From: Ian Stocks [REDACTED] **On Behalf Of** FRS Water and Access
Sent: 14 July 2022 16:13
To: Planning.Responses <Planning.Responses@arun.gov.uk>
Subject: Hydrant condition - BN/65/22/PL Land at rear of Cedar End Eastergate Lane Eastergate PO20 3SJ

HYDRANT CONDITION CONSULTATION WITH PLANNING AUTHORITY

Planning Ref: BN/65/22/PL

Address: Land at rear of Cedar End Eastergate Lane Eastergate
PO20 3SJ

Fire Authority Compliance

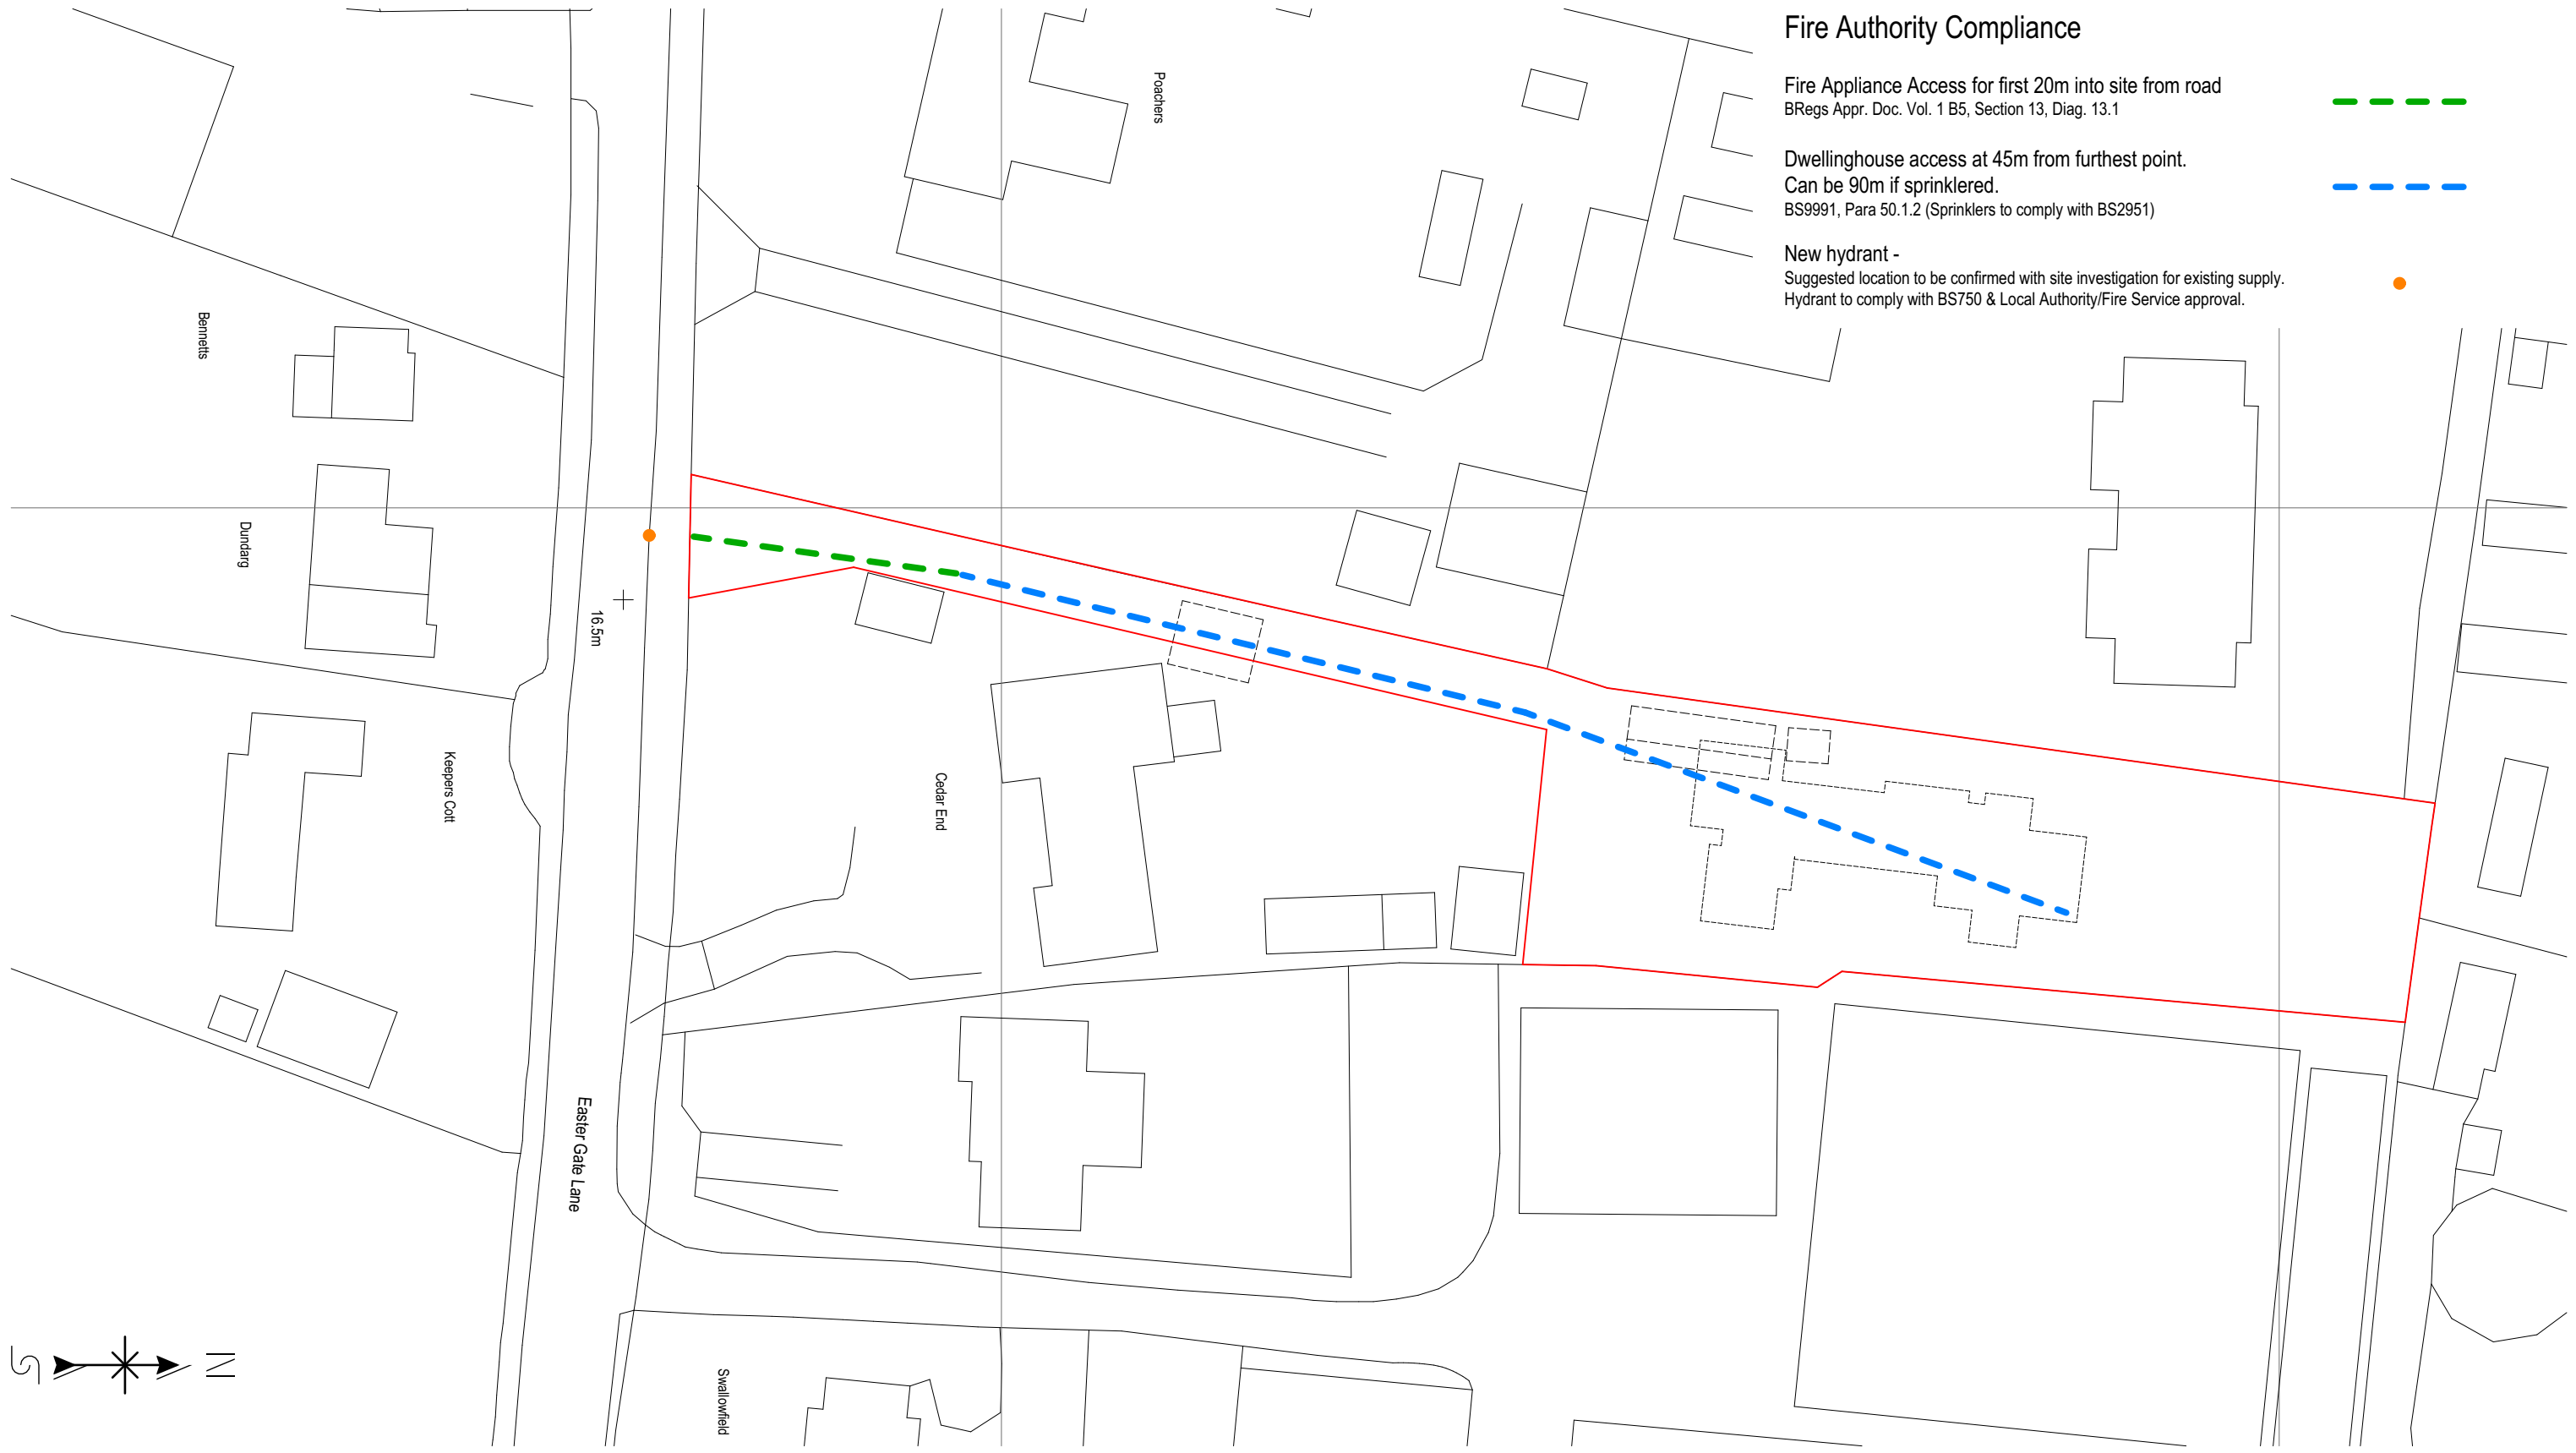
Please find attached a planning condition for application no. BN/65/22/PL for the requirement of an additional fire hydrant. Currently the nearest Hydrant to these proposed property is 260 metres away. The supply of water for firefighting for a domestic premises should be within 175 metres.

Evidence will also be required that Fire Service vehicle access meets with the requirements identified in Approved Document B Volume 1 2019 Edition: B5 Section 13, including Table 13.1 and diagram 13.1.
